Application No: K/55/20/PL
Site Address: 57 Coastal Road Kingston BN16 1SN
Description of works: Demolition & erection of 1 No. dwelling. This application is in CIL Zone 4 and is CIL Liable as new dwelling.

Thank you for your internet representation made on 17th January 2021 which has been recorded as an objection with the comments as follows:

I am commenting on behalf of the East Preston and Kingston Preservation Society.

For ST Charles Homes LTD	
Drawing Proposed Plans&Elevations	
Project La Casa, 57 Coastal Road, West Kingston East Preston BN16 1SN	
Scale	1:100
Date	19.11.2020
Made by Arch. Grygorieva A.A.

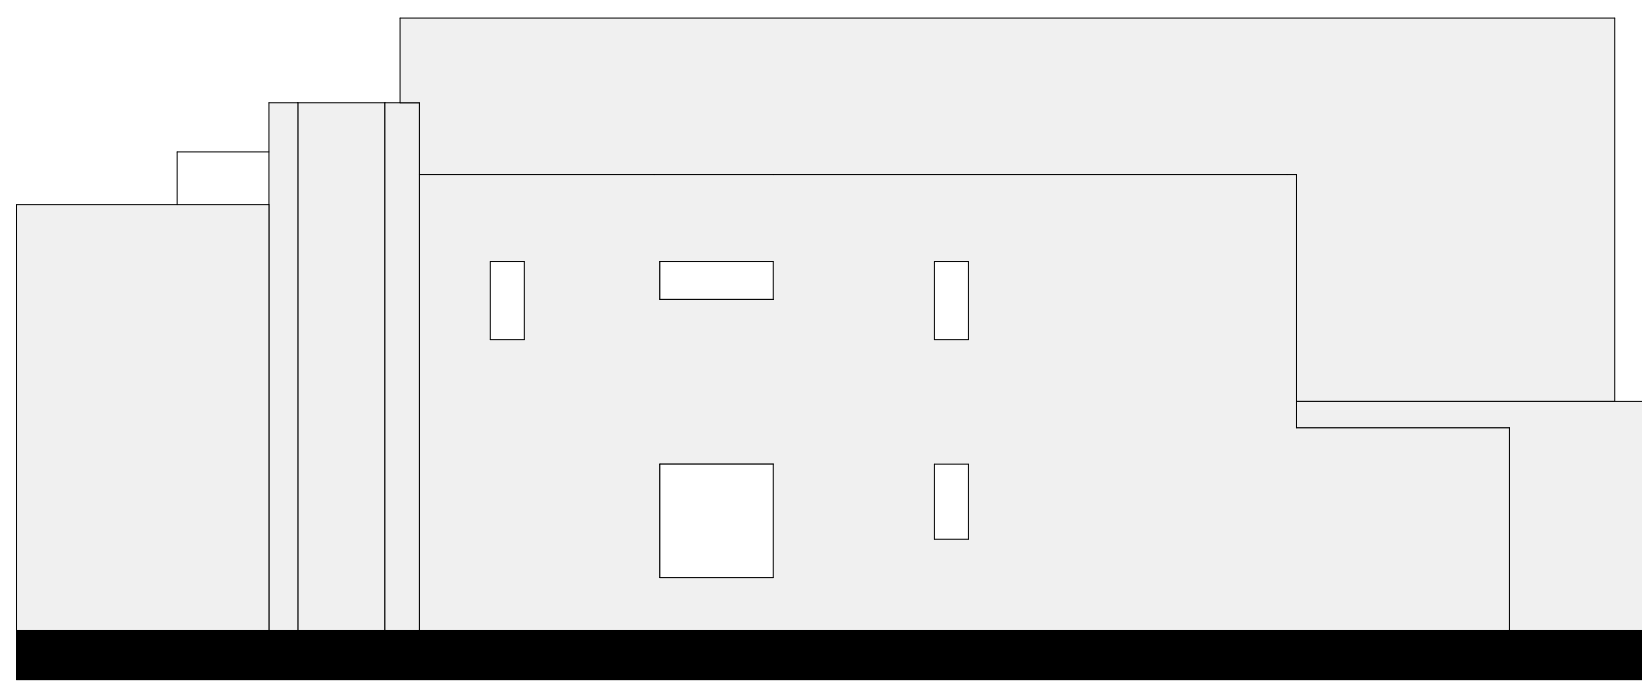
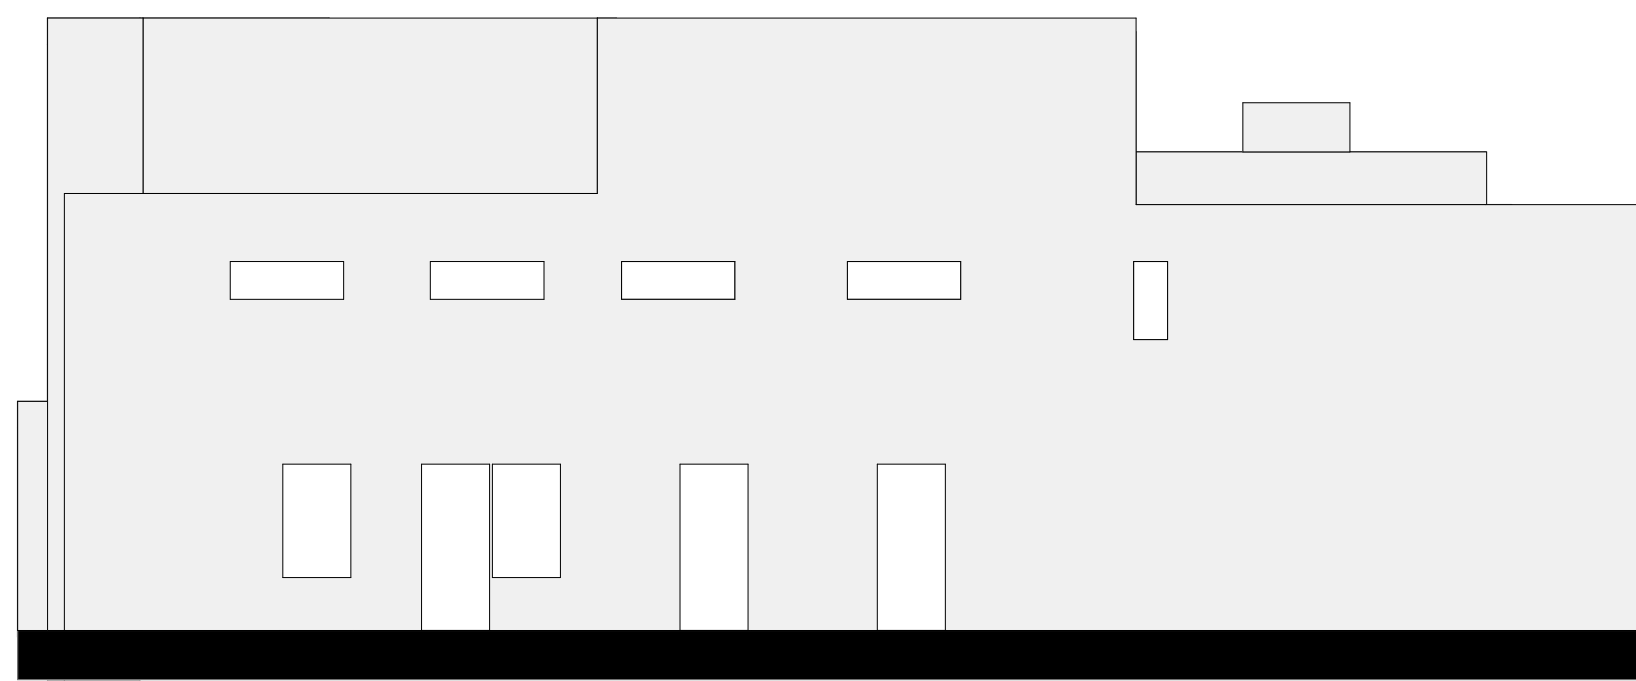
The design of the proposed house could not be further from the objectives of the Local Plan. The images of the street scene show how alien the aggressive facade and severely rectangular form of the house would appear among a row of houses with pitched roofs and more conventional facades. The proposal is very far from reflecting or improving upon the character of the area. Coastal Road does contain a variety of styles, but those near no.55 are conventional in design, and none of the houses further afield are so severely rectangular in form, have so aggressive a street facade, or descend to the vulgarity of mirror glass on the south facade. The effect of reflections from the glass on walkers on the coastal path should be considered. They could be dazzled and alarmed.

This application diverges from the objectives of Policy D DM1 in terms of scale, massing, building materials and design features; in appearance, by demonstrating a low standard of architectural principles and by having a severe impact on users and occupiers of nearby property and land. Planning permission should therefore be refused.
